From: Hornby, Mark [Mark.Hornby@lancashire.gov.uk]
Sent: 23 November 2011 12:10
To: Graeme Thorpe
Subject: FW: Consultation on planning application 3/2011/0497 Kitchens Farm, Bashall Eaves, Clitheroe
Graeme

From: Jane Tucker [mailto:Jane.Tucker@ribblevalley.gov.uk]
Sent: 07 September 2011 17:02
To: ENV EPP Customer Service Area East
Subject: Consultation on planning application 3/2011/0497 Kitchens Farm, Bashall Eaves, Clitheroe

Client's Details,
Mr & Mrs. A. Tootle
Project Details,
Existing Site Plan
Tree Survey
Project Address,
Kitchens Farm
Bashall Eaves
Clitheroe

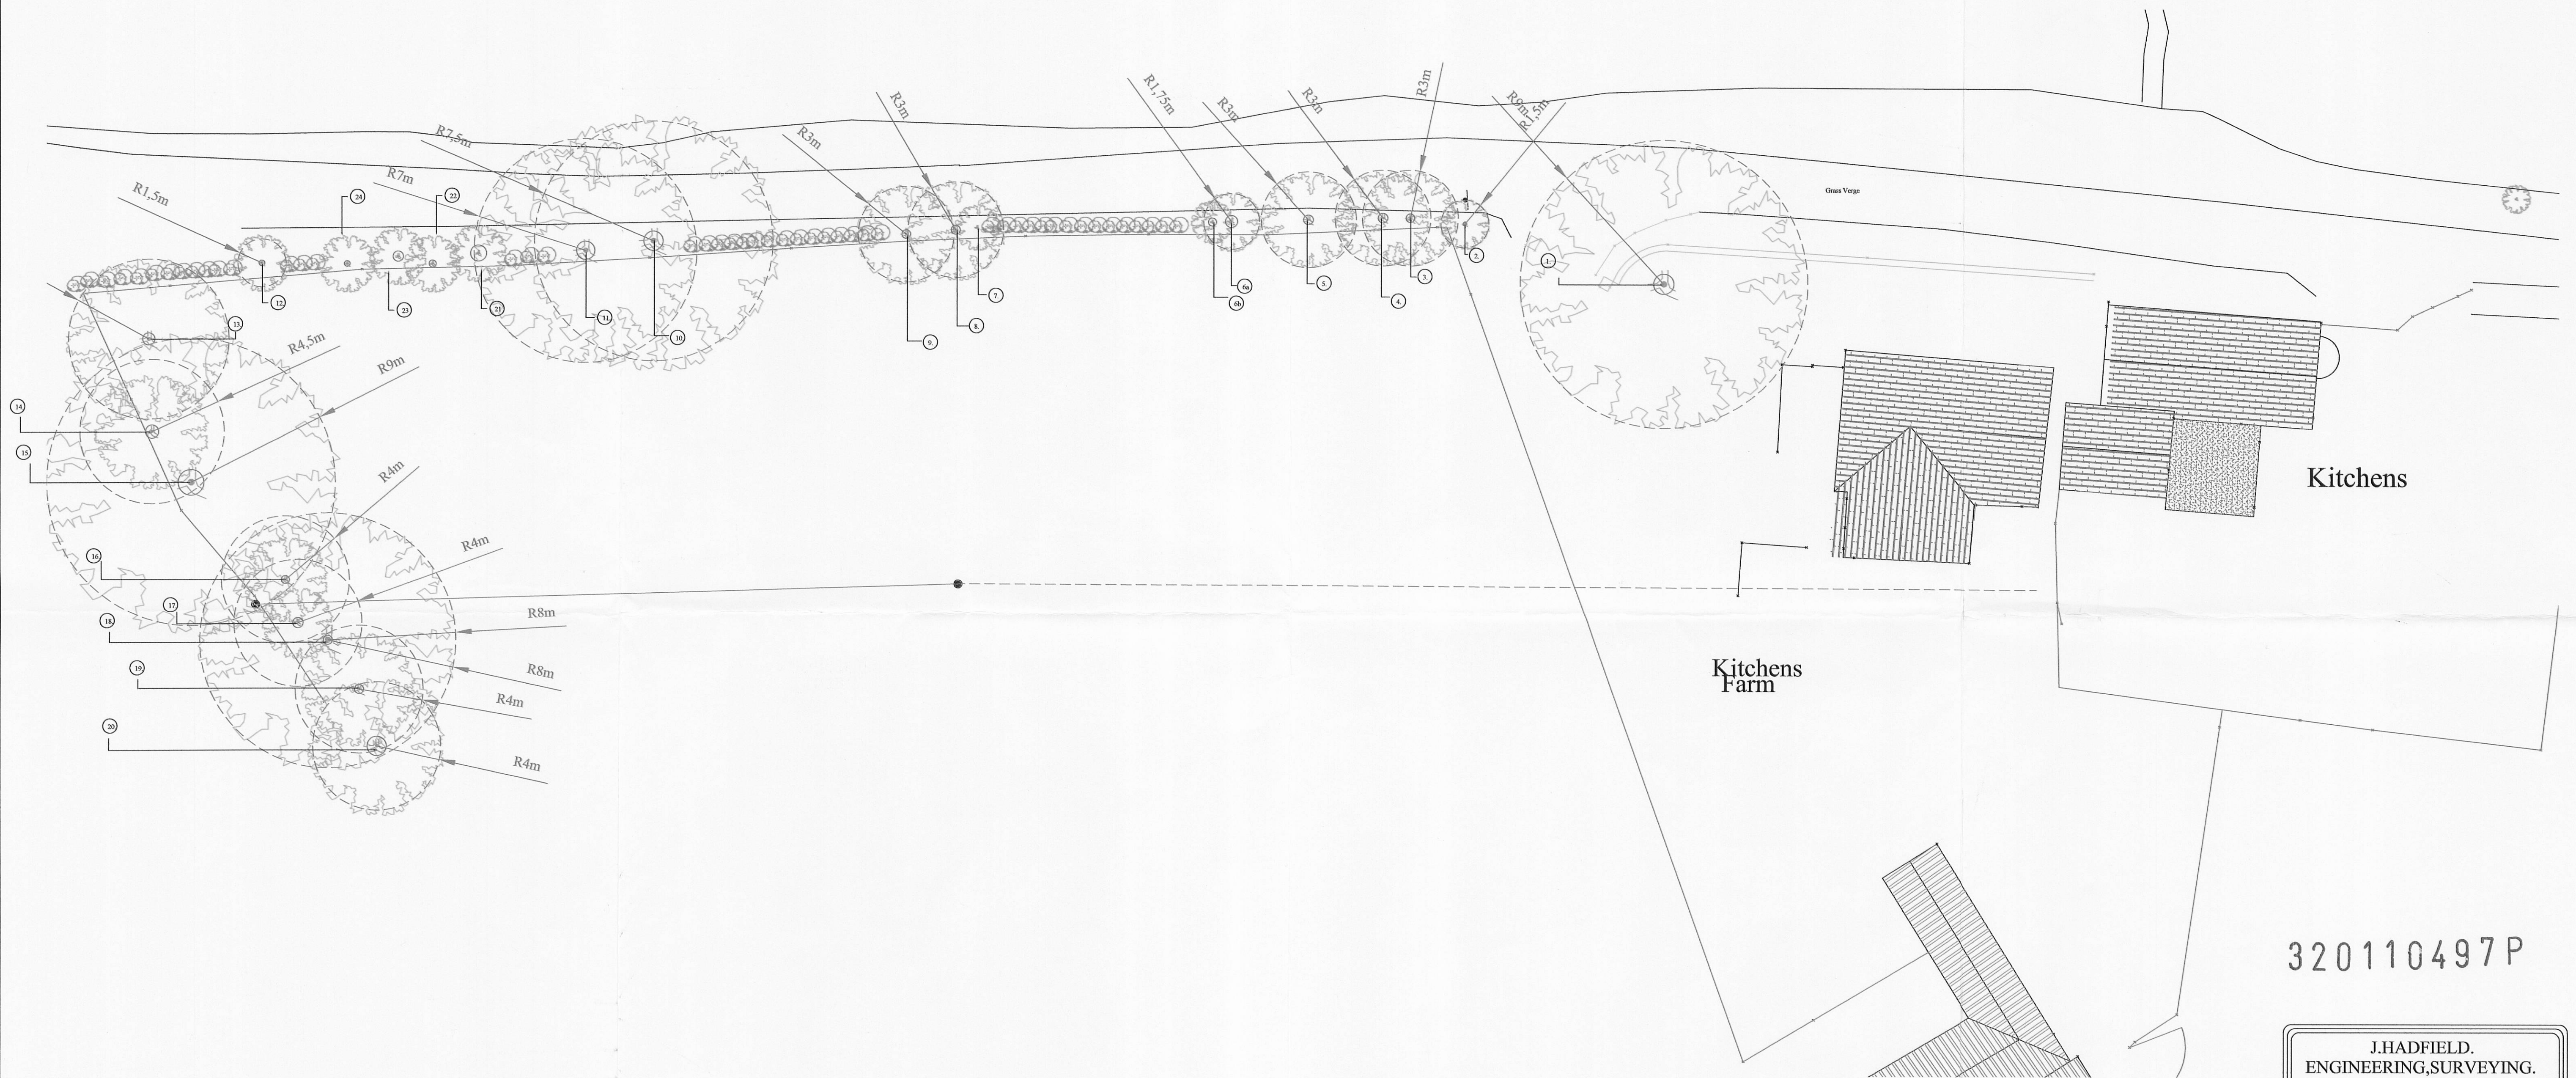
When visiting the site I noted that loose gravel from the existing entrance area was being carried onto Cross Lane. I have no objection to this proposal, subject to the following condition:

1. Before the new access track is used for vehicular purposes, that part of the existing entrance extending from the highway boundary for a minimum distance of 5 metres into the site shall be appropriately paved in tarmacadam, concrete, block pavements, or other approved materials Reason: To prevent loose surface material from being carried onto the public highway thus causing a potential source of danger to other road users.
